19 August 2022

Wollongong Council submission

Development	Bulk Liquid Terminal - State Significant Development Request to provide advise on EIS - SSD-33042483
Location	Lot 1 DP 122721 Lot 1 Foreshore Road PORT KEMBLA NSW 2505

Figure 3.2: Nominated Construction Truck Routes

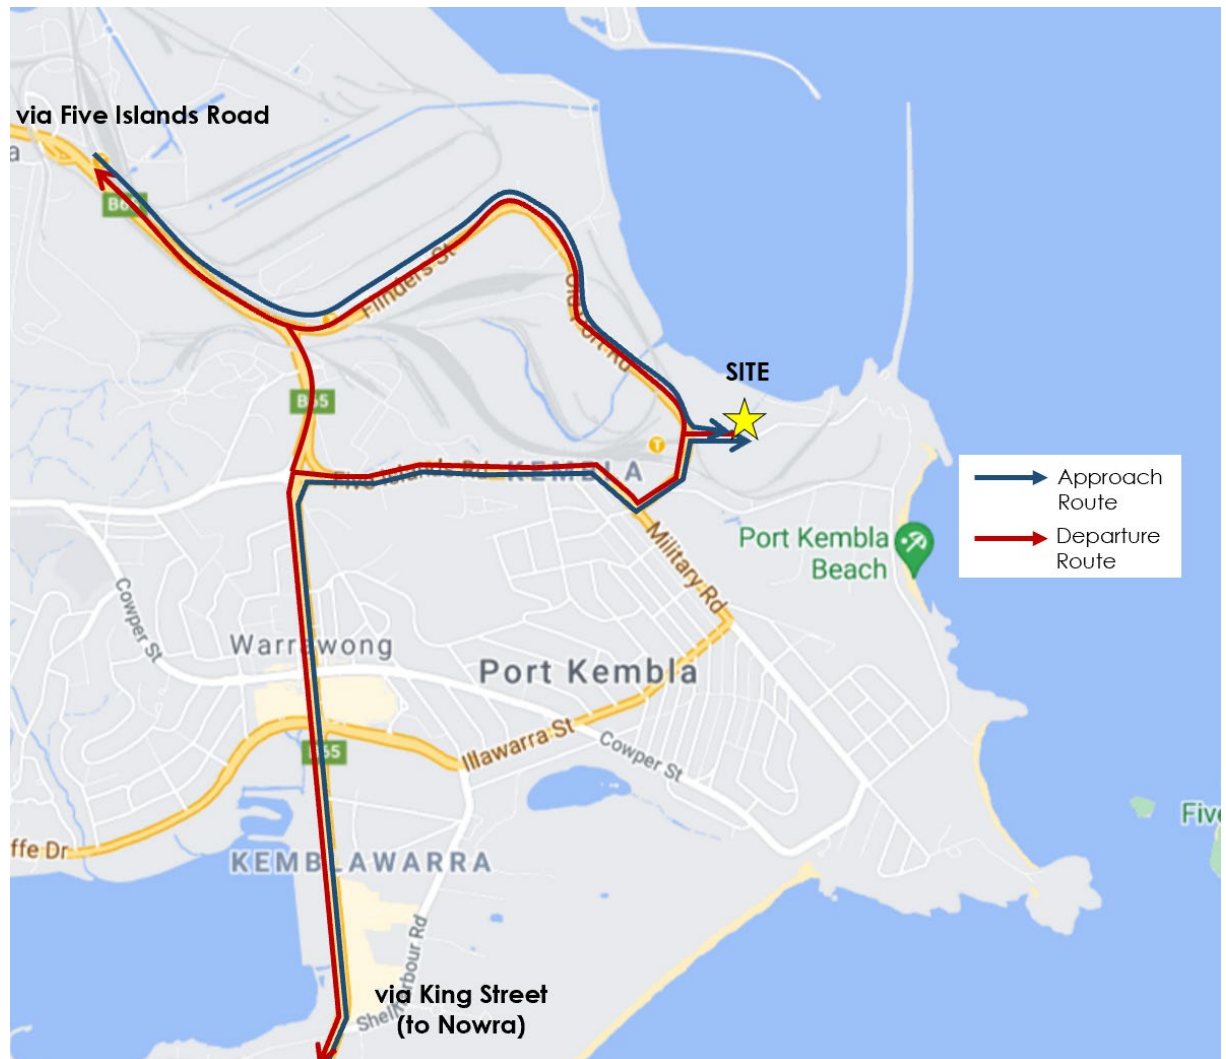
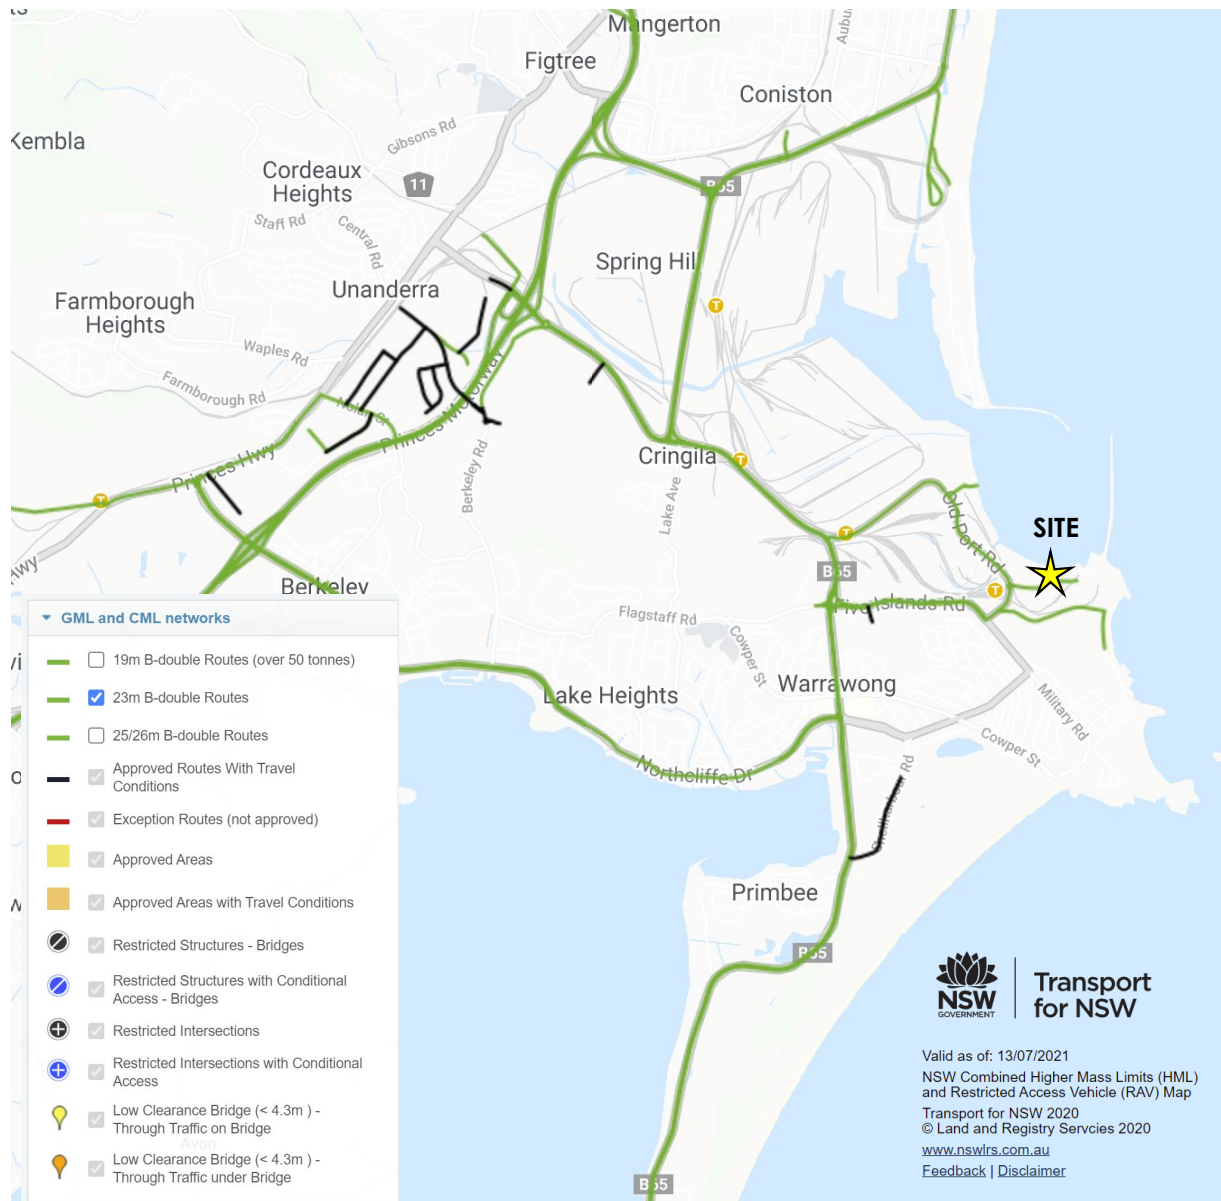
Whilst the utility and desire for an alternate travel route is understood, Option 2 presents increased environmental risks due to this route travelling through residential areas. Ethanol is a Dangerous Good Class 3, Packing Group 2 flammable liquid and an incident such as a tanker pollution event in or around the Windang Bridge and Lake Illawarra would have a devastating effect on the environment resulting from spillage as well as other chemicals or fire extinguishment and clean up. Transport related noise would also have a greater effect on more sensitive receivers in the Option 2 route.

It is unclear under what circumstances trucks would utilise Option 2 and how that would be monitored or regulated. Further, if an A-double tanker is enroute and discovers option 1 to be congested, that tanker would not appear to be able to utilize option 2 due to the limitations on road freight identified above.

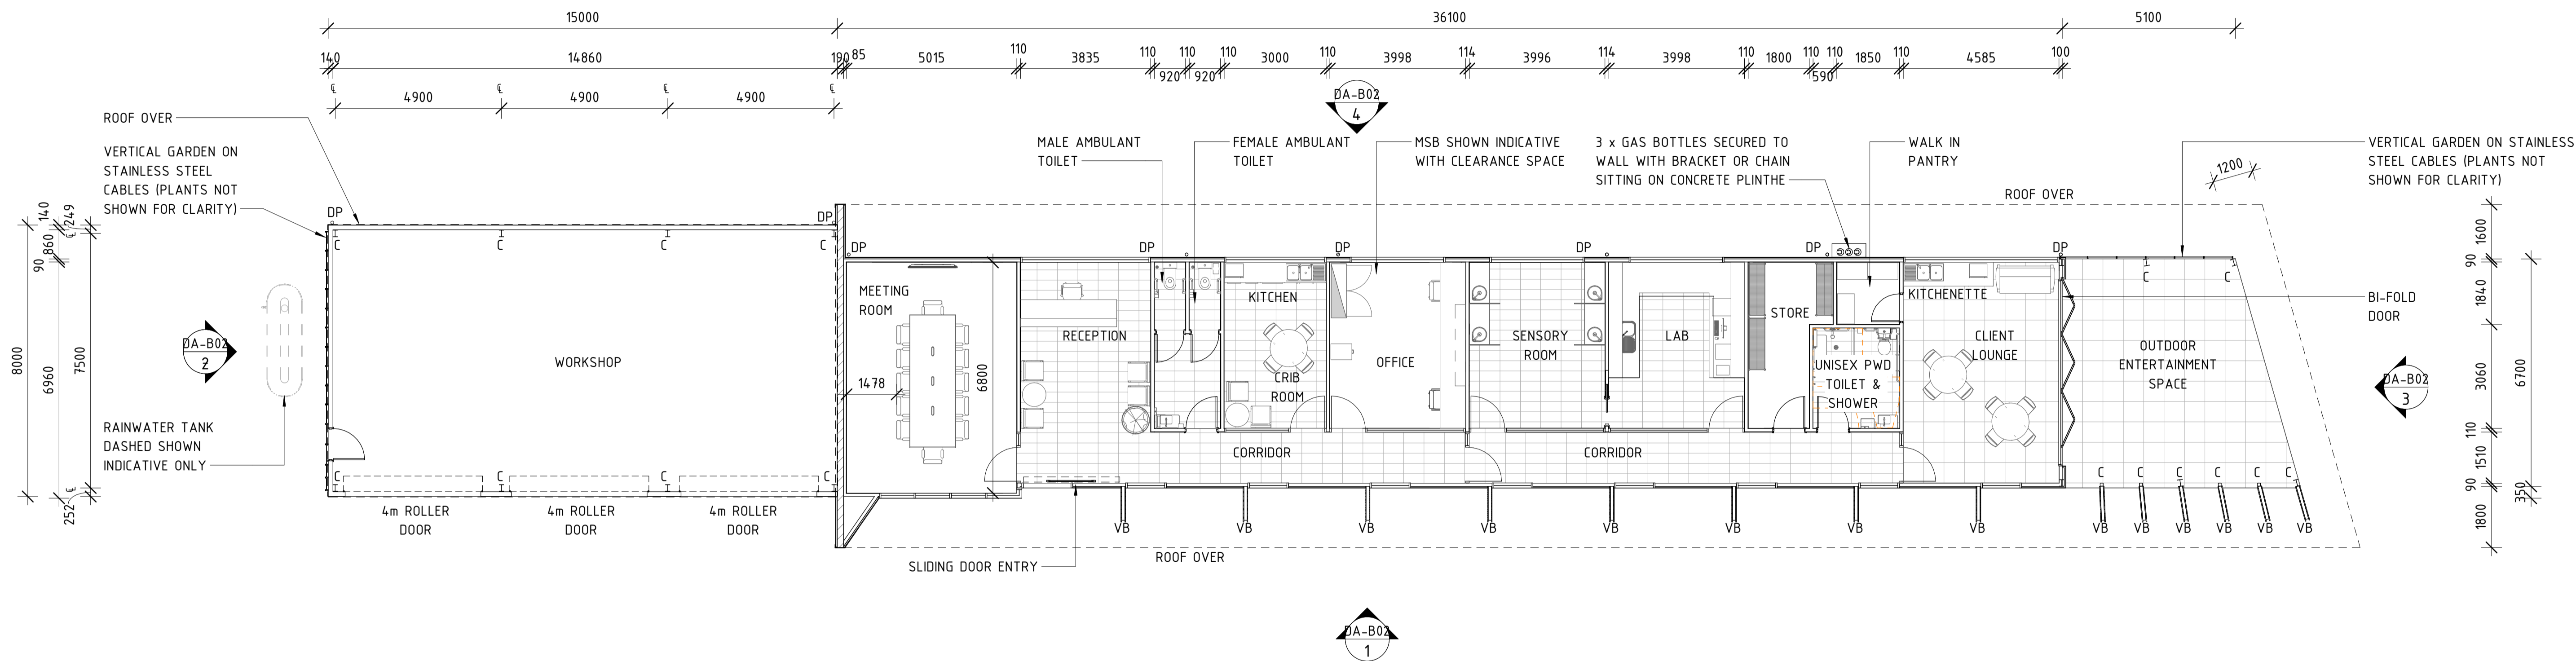
Opportunities should be investigated to make the proposed 6 large white storage facilities more visually recessive or options for alternative siting to minimise visual impact.
